This document provides responses to the traffic and transport related matters raised by the City of Sydney Council (Council) in their submission to the site at 13-17 Oxford Street and 2 Verona Street, Paddington (SSD – 87245208). The Council submission is dated 5 May 2026.

**Table 2: Responses to Council comments**

**Job Title**  
 13-15 Oxford St, 17 Oxford St  
 & No 2 Verona St, Paddington

**Drawing Title**  
 Turning Paths

Drawing Title
BASEMENT 2 PLAN

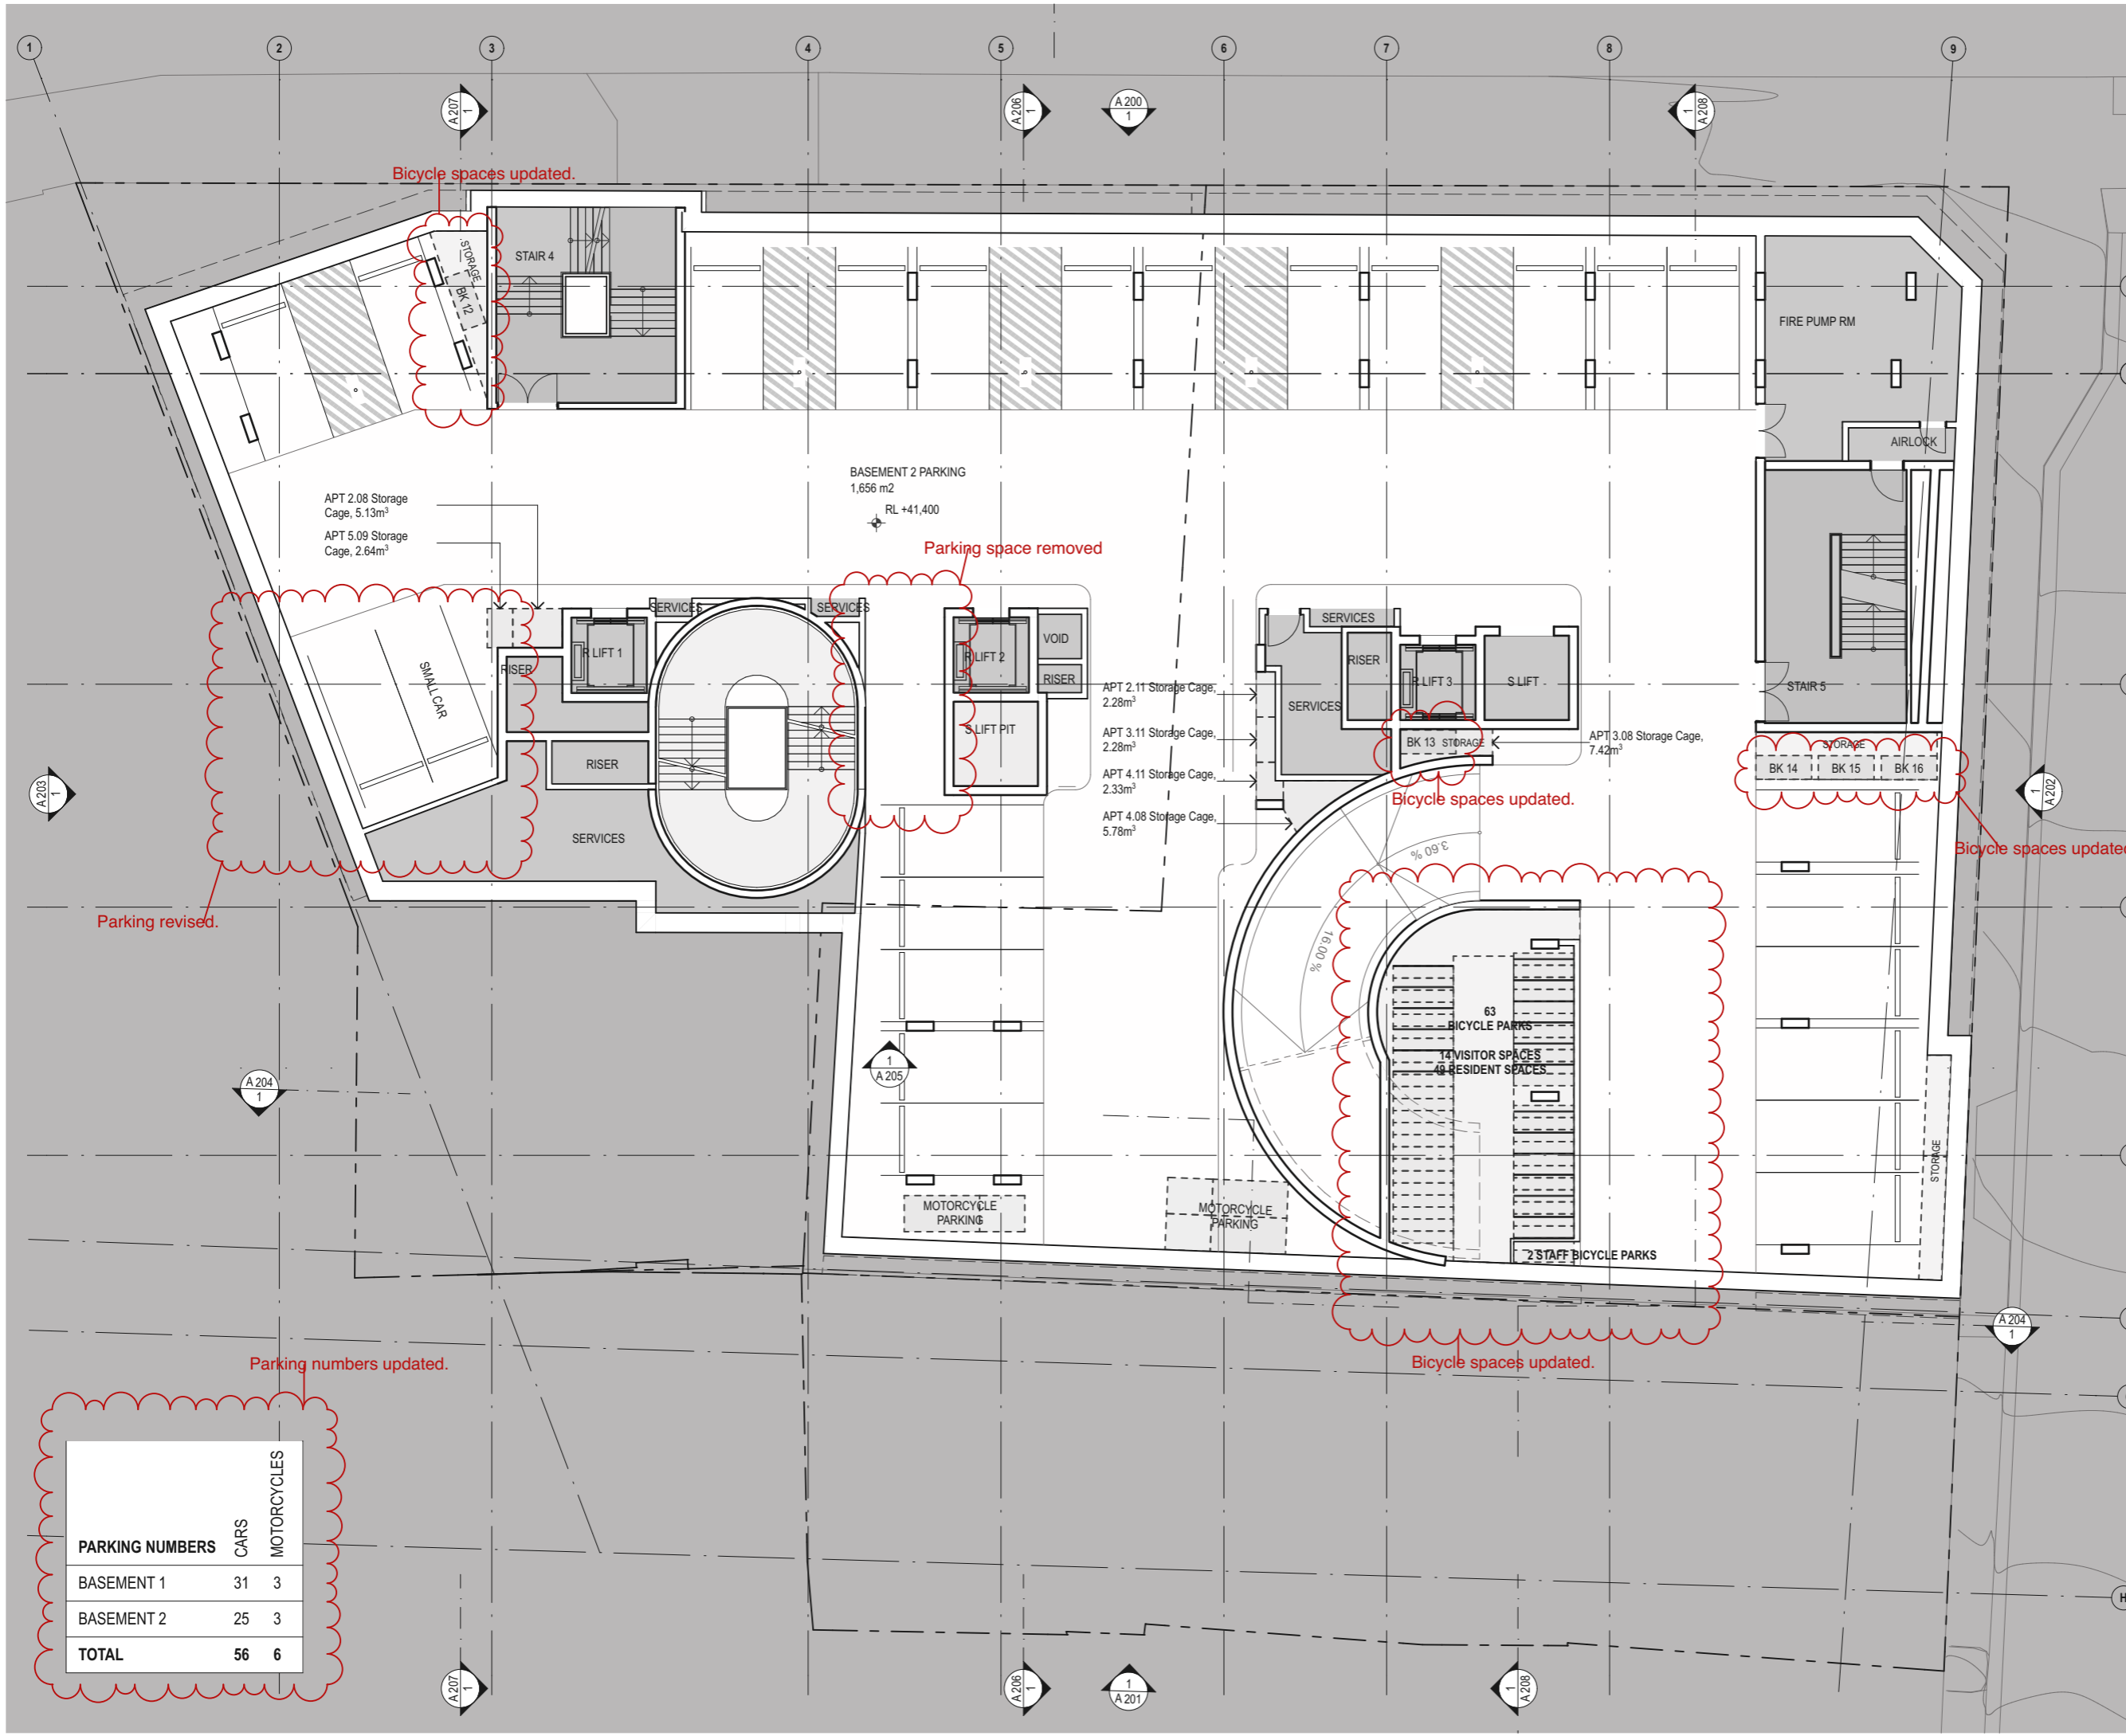
CoS Item Number	Council Comment	JMT Consulting Response
12.2	<p><i>Vehicle access and car park design</i></p> <p>The following outstanding information and amendments are required regarding the proposed vehicle access and car park design:</p> <ul style="list-style-type: none"> <li>i. Updated swept paths of the revised 6.5m driveway design.</li> <li>ii. The revised plans show the gradient along the vehicle ramp to/from Verona Street varies from 5% to 10% (previous documentation stated 5% grade). This does not comply with AS2890 series and introduces an unacceptable crossfall for heavy vehicles.</li> </ul> <p>Gradients must not exceed 5% for 6m prior to the building line and the maximum rate of change of grade is 6.25%. The driveway ramp must be updated to provide a compliant ramp grade, grade transitions and crossfall for heavy vehicles.</p>	<ul style="list-style-type: none"> <li>i. Swept paths for the driveway, including for passenger vehicles and a 10.6m City of Sydney waste truck, are provided as Appendix B of this document</li> <li>ii. AS2890.1 requires a maximum gradient of no more than 5% so as to allow exiting drivers to adequately view pedestrians and vehicles on the adjoining roadway. Therefore this requirement applies to exiting vehicles.</li> </ul> <p>The proposed design complies with this requirement by providing for a gradient of 5% on the path of the exiting vehicle – noting the entering vehicle (on the southern side of the driveway) will be positioned on an internal waiting bay. This is indicated in the swept paths provided as Appendix B of this document. All internal ramp gradients and transitions as submitted in the architectural plans comply with the relevant requirements of AS2890.1.</p> <p>The comment around the crossfall of the ramp is noted, however Council must recognise that Verona Street falls sharply from south to north resulting in different starting levels at either end of the ramp. In this context a crossfall on the internal ramp is unavoidable.</p> <p>The vehicle entry arrangements including swept paths and ramp crossfalls will be the subject of further design resolution during the detailed design phase of the project, with sign off from a suitably qualified engineer required to confirm the layout conforms with the requirements of AS2890.1 prior to the issue of a Construction Certificate.</p>

Drawing No.
A 103

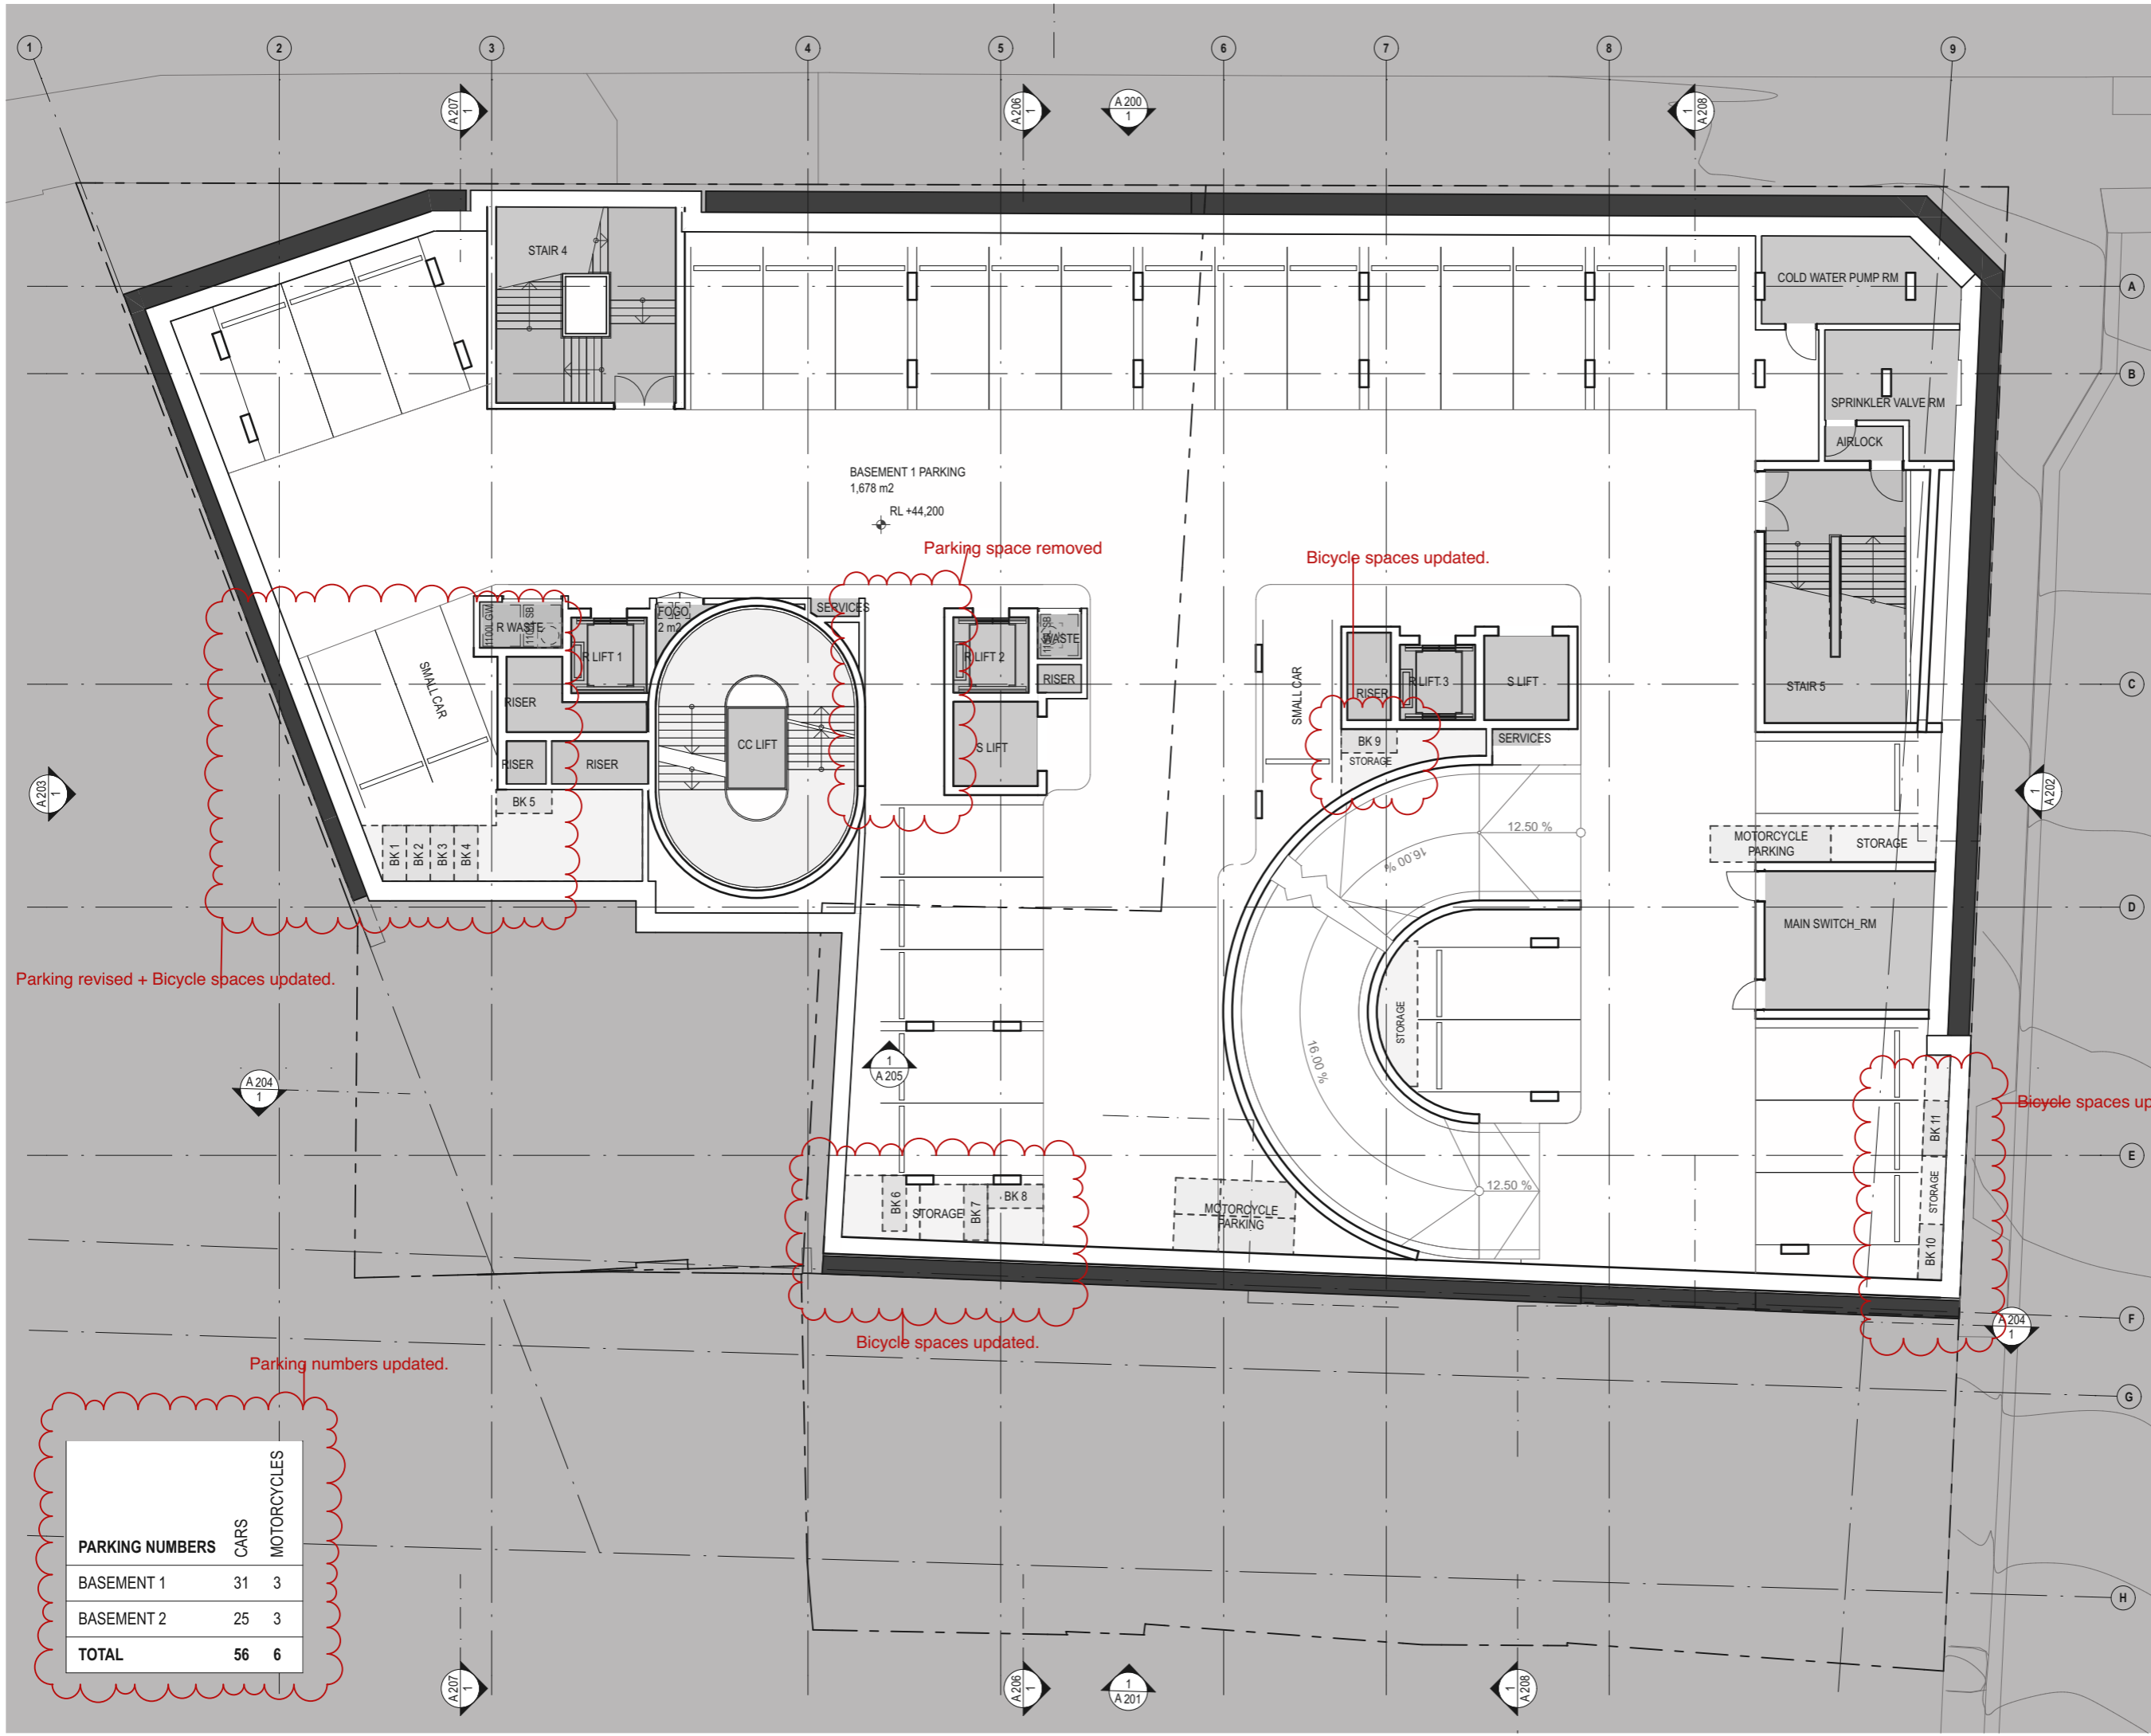
CoS Item Number	Council Comment	JMT Consulting Response
12.1	<p><i>Car parking</i></p> <p>The proposed 58 residential parking spaces for the development still exceeds the maximum 50 residential car parking spaces permitted under clause 7.5(1)(b) of the Sydney LEP 2012 and is contrary to clause 7.3 of the Sydney LEP 2012.</p> <p>It is reiterated that in this instance, the Sydney LEP 2012 parking rates are not more onerous than those set out in clause 19 of the Housing SEPP and therefore prevail. The development must be amended to comply with the car parking maximums set out in the Sydney LEP 2012.</p> <p>Further, it is noted that the revised plans show 2 small parking bays that do not comply with AS2890.1 series and are required to be removed.</p> <p>A condition requiring a car share bay has been recommended within Annexure B.</p>	<p>The car parking provision has been reduced to 56 (from 58) spaces compared to the RTS submission. This level of car parking is considered suitable to accommodate resident demands and provides an appropriate balance between meeting the parking needs of future residents and managing the impacts of traffic generation. Although the total car parking of 56 spaces is slightly below the minimum requirement of 61 spaces under the Housing SEPP, it remains below the maximum number of spaces permissible under the Sydney LEP – see Appendix B. In this context the proposed level of car parking is considered acceptable.</p> <p>The small parking bays identified by Council have been removed from the updated architectural plans, bringing the total number of parking spaces down to 56.</p> <p>In relation to car share there is no requirement under the Housing SEPP 2021 to provide for this on the subject site. There are numerous existing GoGet car share pods in close walking distance of the site as illustrated in the figure below. Therefore no dedicated on-site car share space is considered warranted for the subject site.</p>
